26th November 2012

**Town & Country Planning Act 1990 (as amended)  
Town and Country Planning (Development Management Procedure) (England) Order 2010 (as amended)  
Application for Planning Permission**

**Development** Remove lean-to porch and construct a single storey extension to the rear of the property.  
**Location** 73 Elm Grove Barnham Bognor Regis

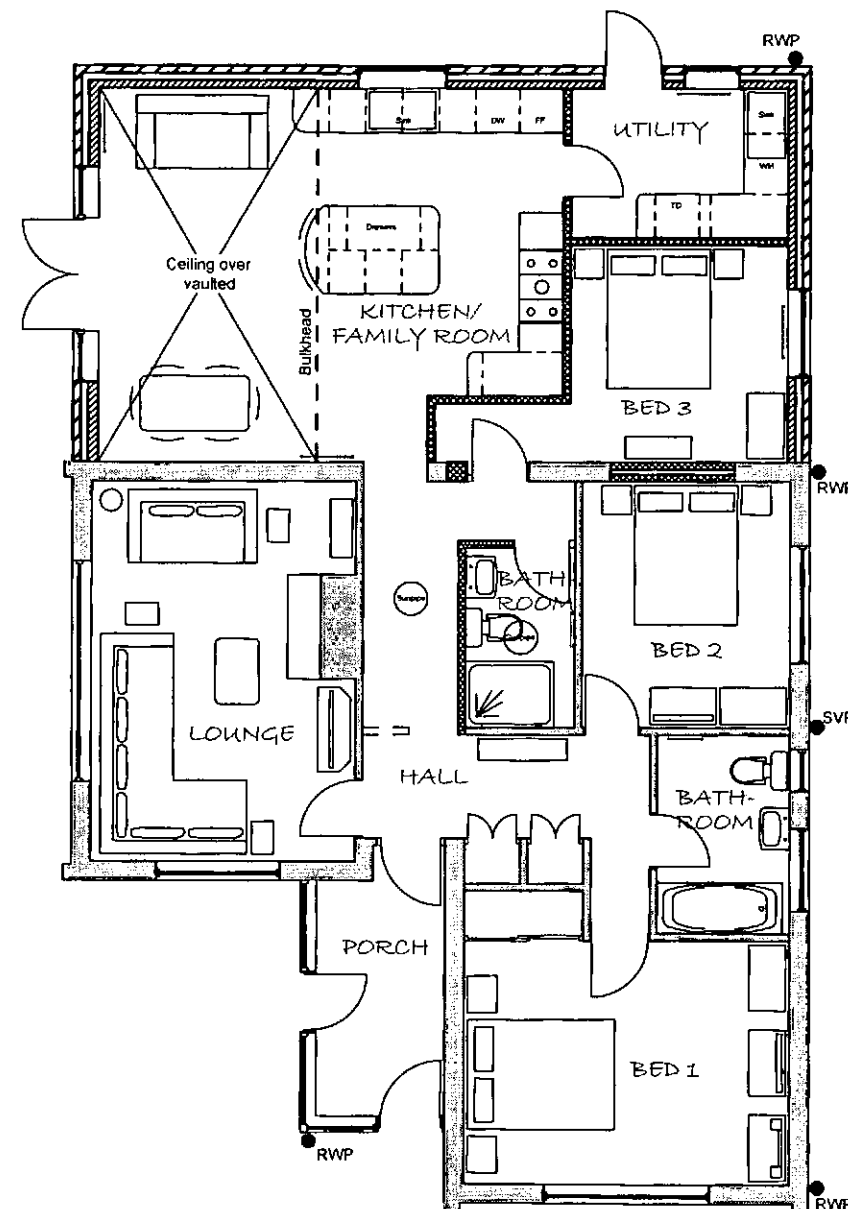
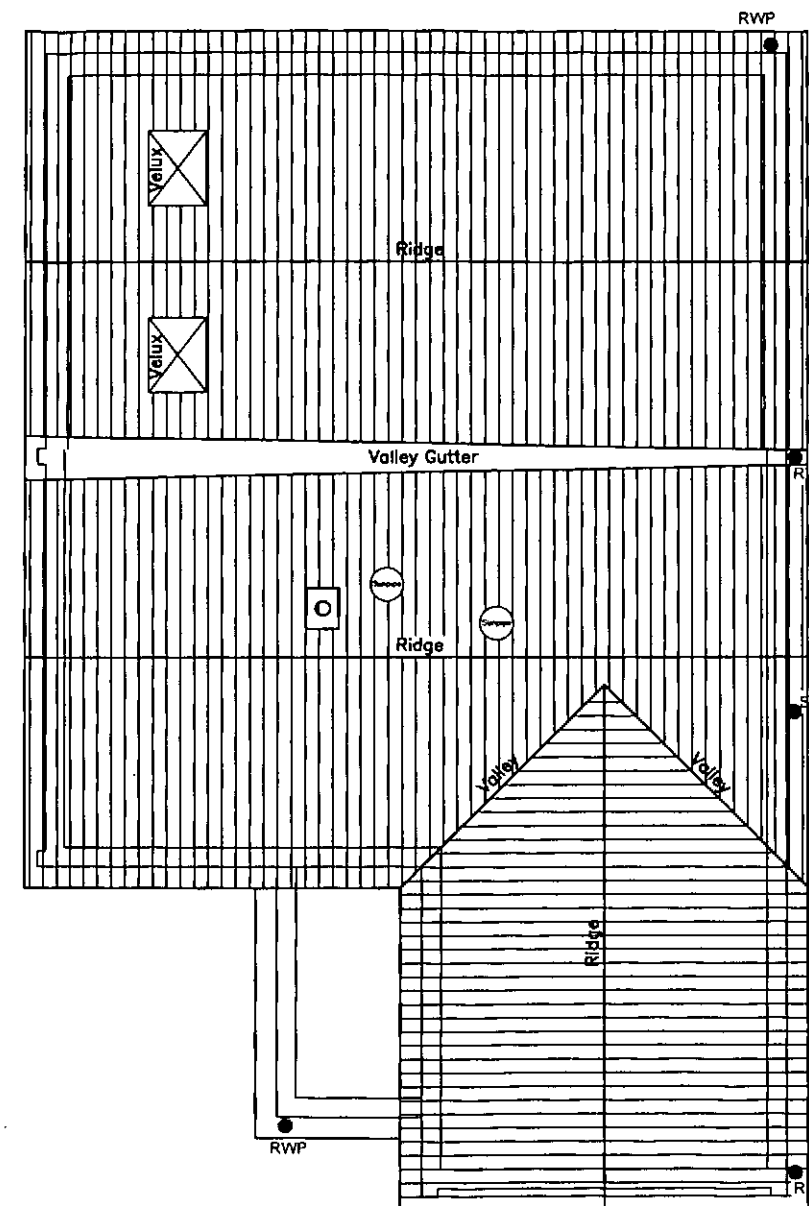
The proposed South and West floor plans do not accord with the proposed South and West elevations. Please amend accordingly. 26/11
